Your Reference	SSD 9670
Our Reference	NCA/3/2019
Contact	Luca Chudleigh
Telephone	9806 5600
Email	LChudleigh@cityofparramatta.nsw.gov.au

28/06/2019

**RE: WESTERN SYDNEY UNIVERSITY INNOVATION HUB (SSD 9670) – 2-6
Hassall St, Parramatta**

Sheet Name
LEVEL 10

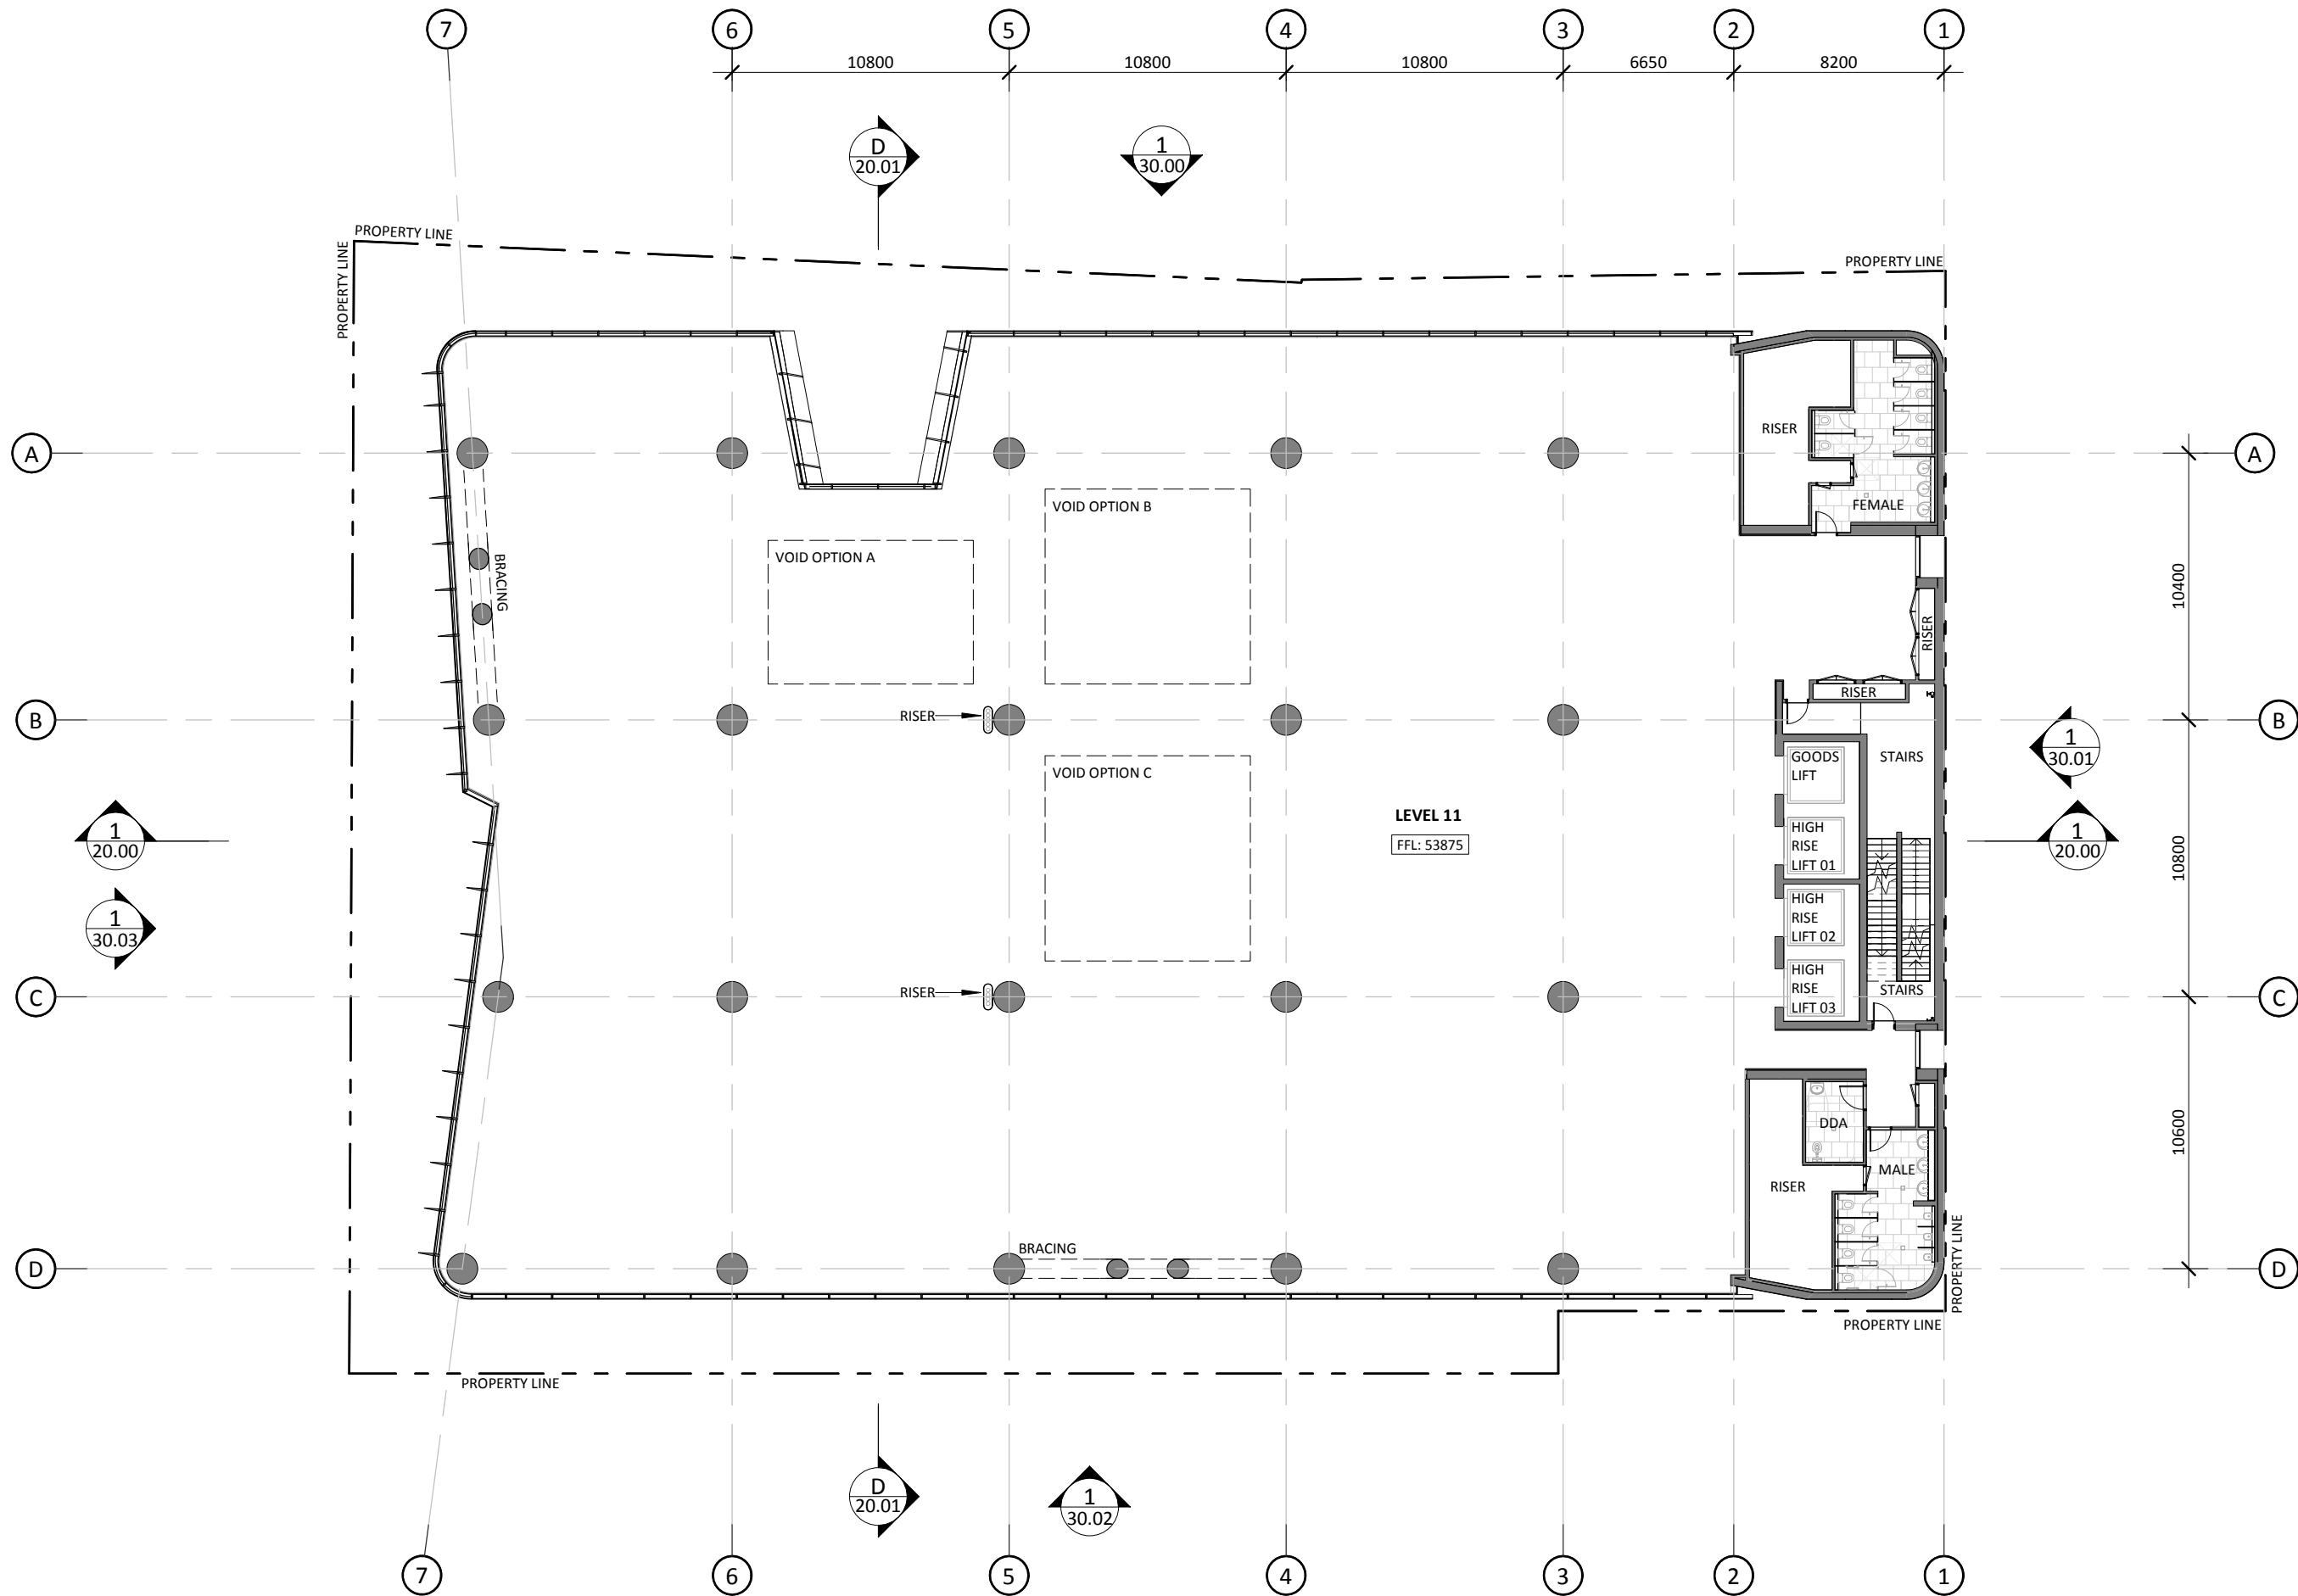
- All doorways from the level 10 and 12 areas leading to the terrace must provide low level thresholds with a construction tolerance of no more than 3mm.
- Ensure the doors from both floors leading to terraces provide a clear opening of 850mm including the active leaf of any set of double doors. This should also apply to the doors providing access to amenities.
